14 January 2012

Thank you for the opportunity to provide comments related to MP 09\_0177 – McWilliam's Winery Expansion. Griffith City Council has had several pre-lodgement discussions and meetings regarding the preparation of the EA with the applicant and most of Council's recommendations were included in the draft Environmental Assessment including the provision of stormwater management plan for the entire site (existing and proposed hardstand areas and structures), odour modelling for both the winery site and the wastewater storage dams and carparking analysis. Griffith City Council previously reviewed the draft Environmental Assessment for adequacy and provided a letter to the Department of Planning on 13 September 2012. The following is a summary of the review:

Project: ENVIRONMENTAL IMPACT STUDY  
Title: PRELIMINARY PROPOSED DEVELOPMENT SITE MASTER PLAN STAGING

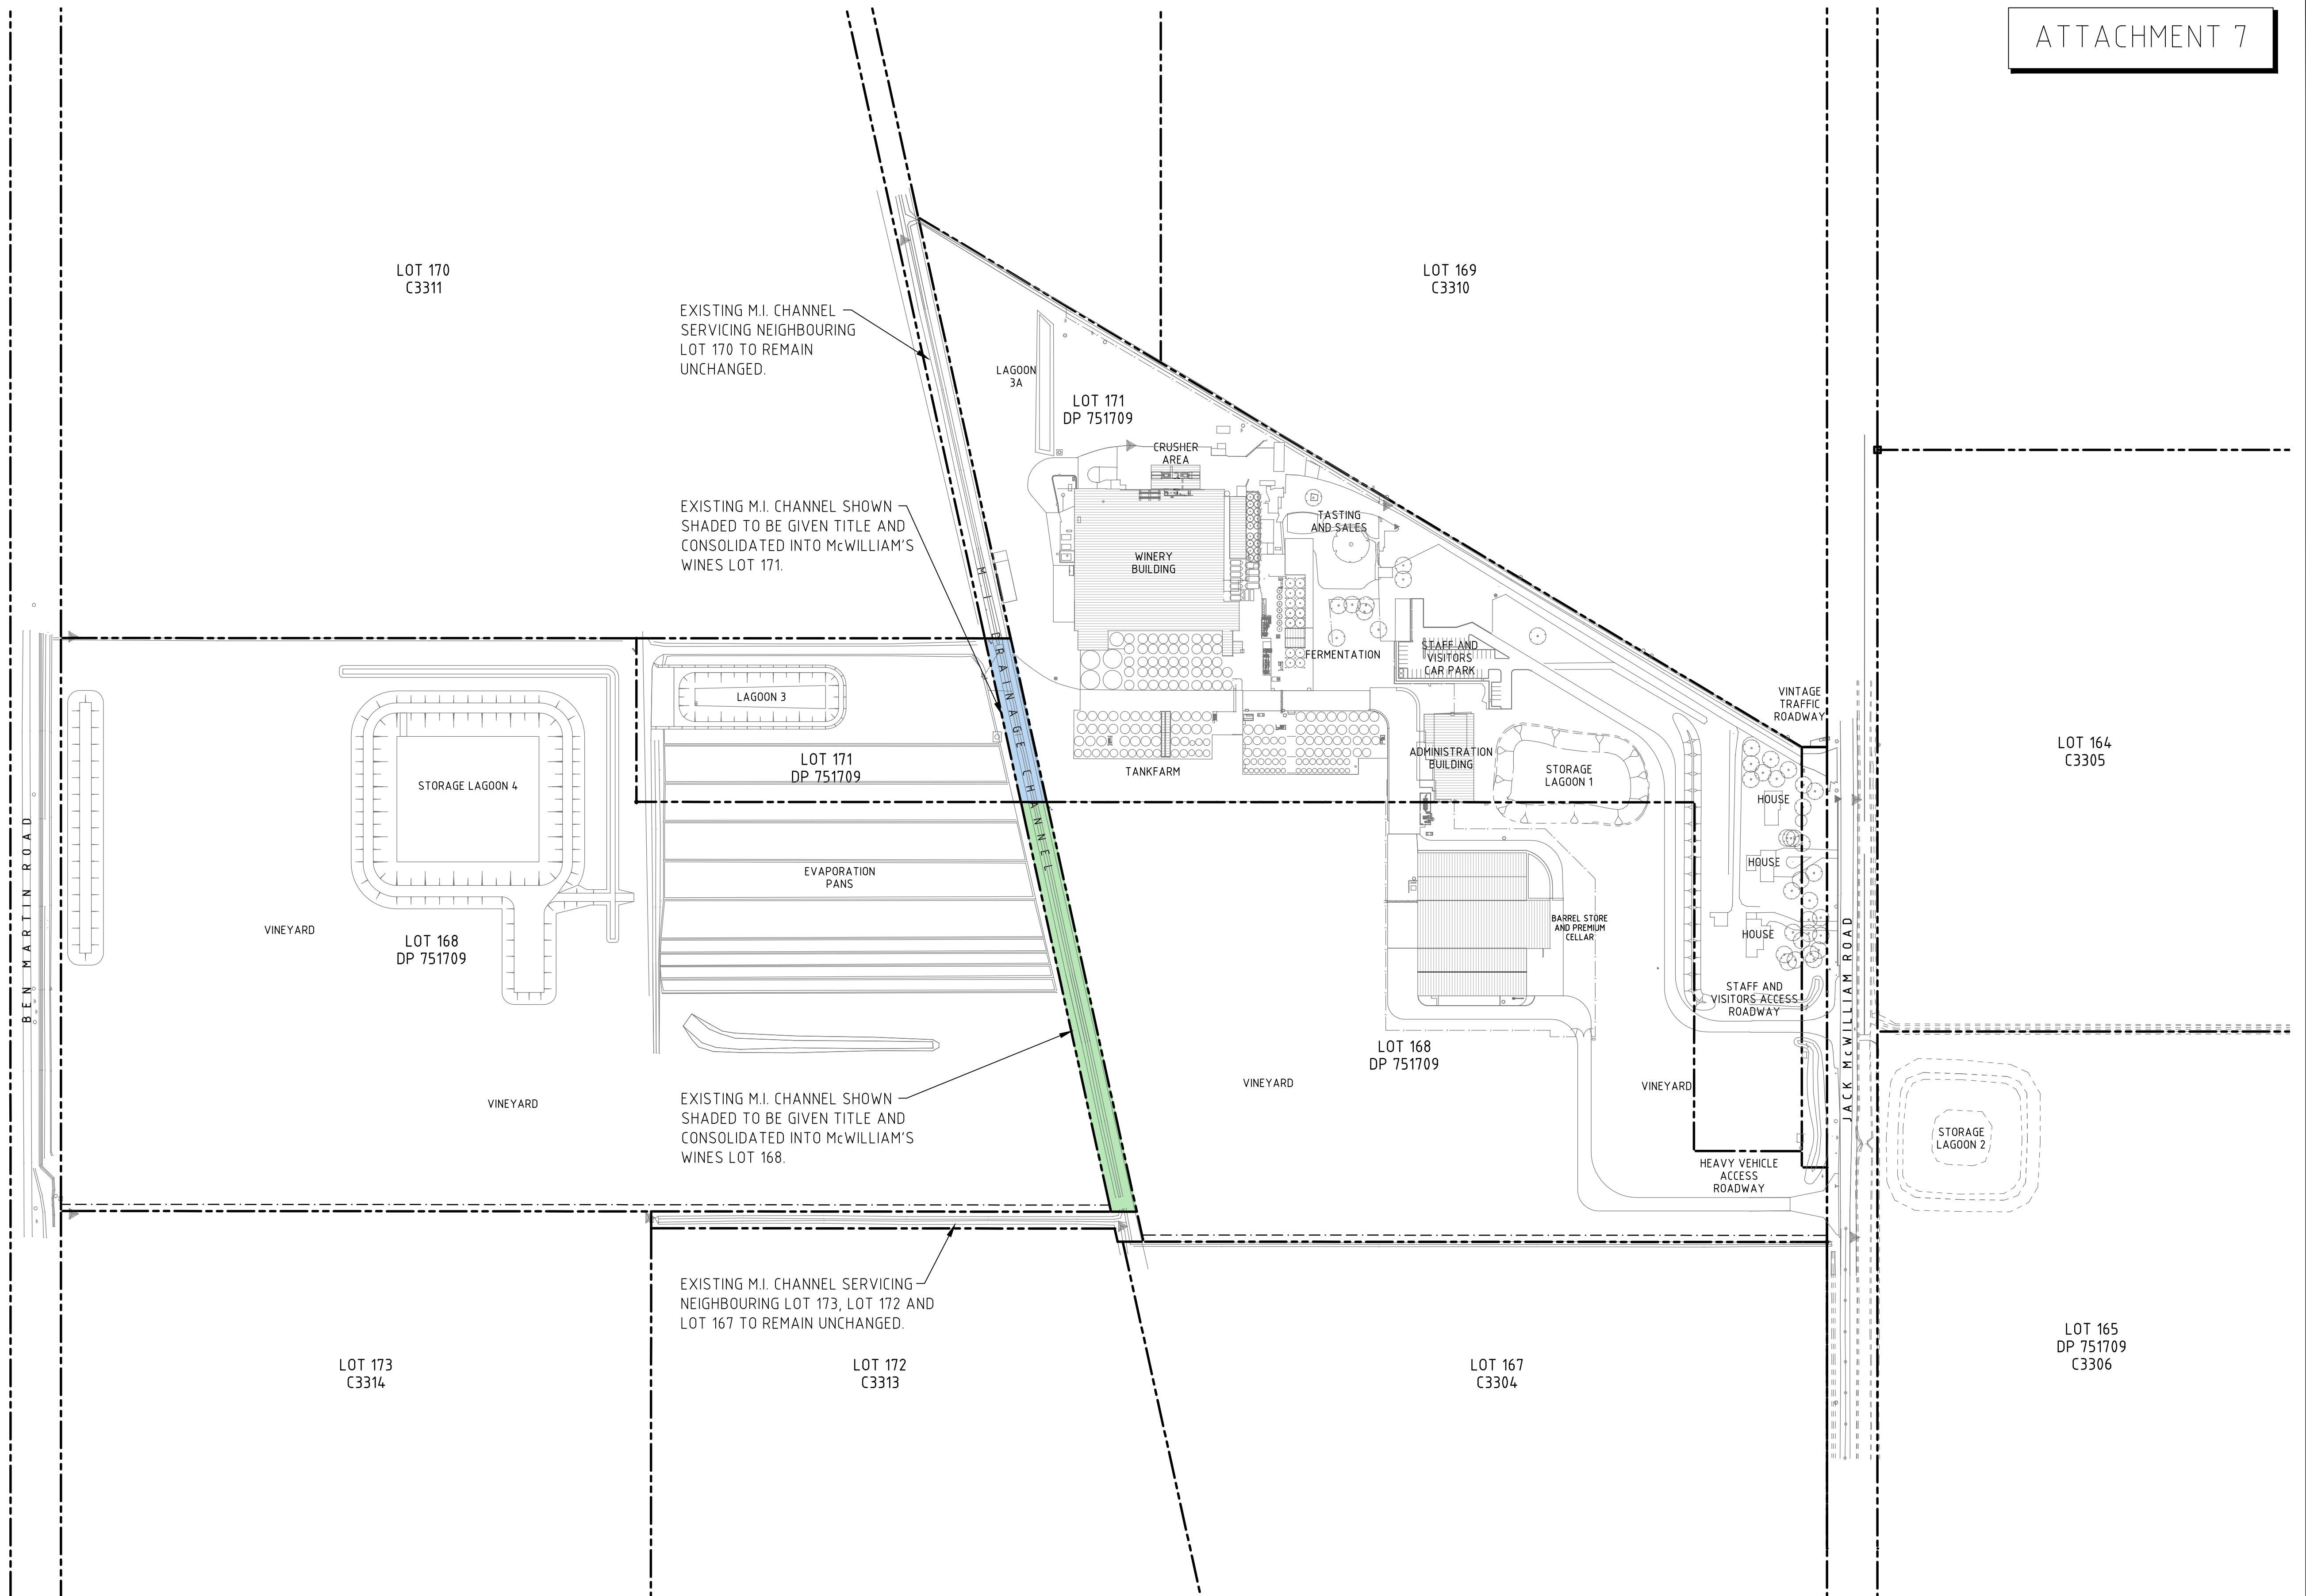
- *The EA only briefly touches on the "Likely Staging of the Project"*
    - *Council would like the applicant to indicate which attributes of the project will be required to be implemented at which stage of production capacity. For instance, will the entire wastewater design concept be implemented prior to any increase in production? Or will components of the entire design be staged according to targets related to increases in production?*
